From: Nicola Moore on behalf of Planning.Responses
Sent: 13 November 2019 09:39
To: Planning Scanning
Subject: FW: BN/85/19/DOC - Land rear of Lillies, Yapton Road, Barnham

From: Sarah Burrow [REDACTED]
Sent: 12 November 2019 15:16
To: Michael Eastham [REDACTED]
Cc: Planning.Responses <[REDACTED]> Paul Cann [REDACTED]
Subject: RE: BN/85/19/DOC - Land rear of Lillies, Yapton Road, Barnham

There appears to be some confusion about the supplied Flood Risk Assessment FRA. It is not approved by ADC, I am unable to see how the applicant has come to this conclusion. If the Drainage Engineers had been satisfied with the level of infiltration testing and groundwater monitoring that was outlined in the FRA then they would not have included the requirement for them in the condition that was applied to the application. No long term monitoring of the groundwater conditions was completed.

SFA10C Headwall
SFA1 450 Outfall Safety Grille
3 Sided Kee Klamp

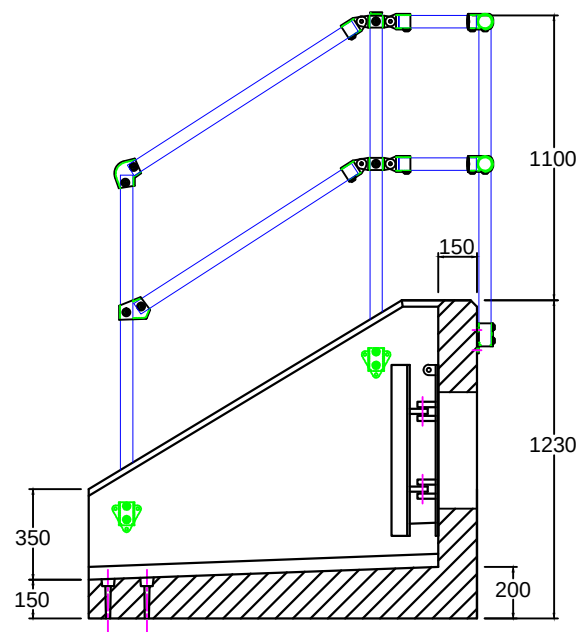
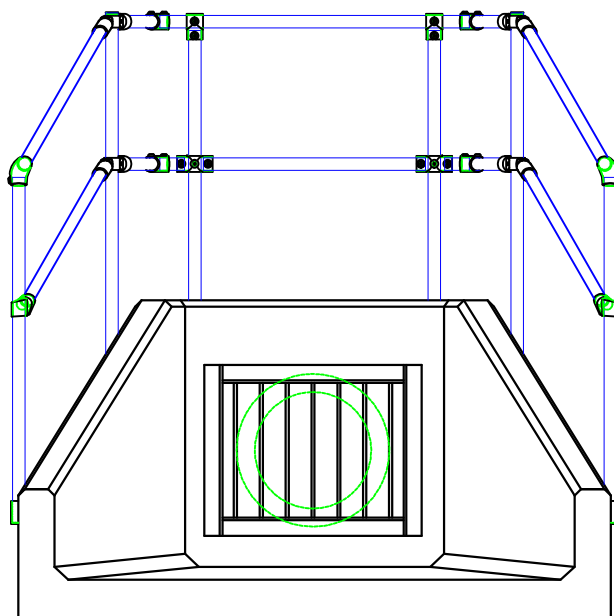
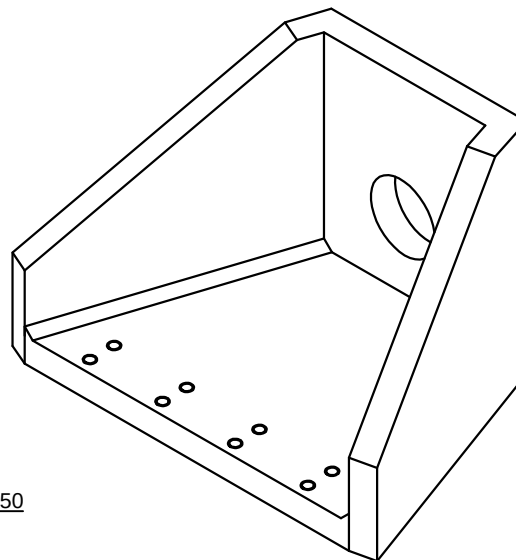
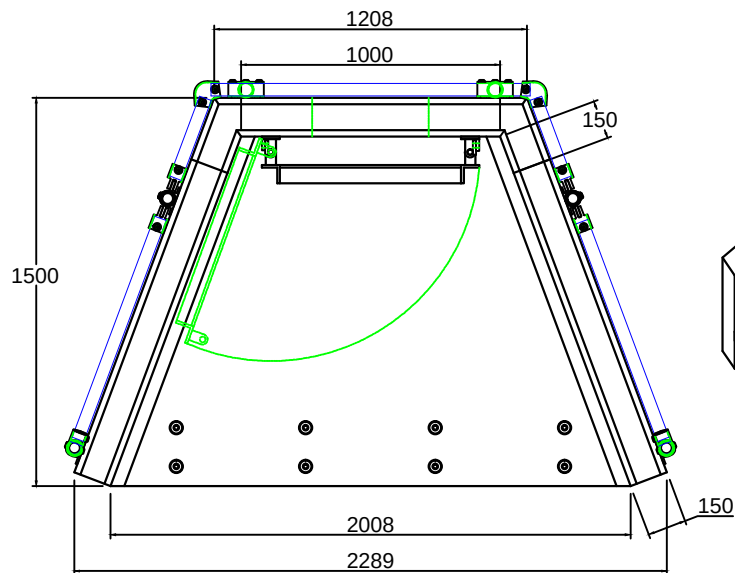
6. The proposed invert level of any outfalls must clearly be shown on plan with hard and soft ditch bed levels also provided. See attached drawing 600 & 601.
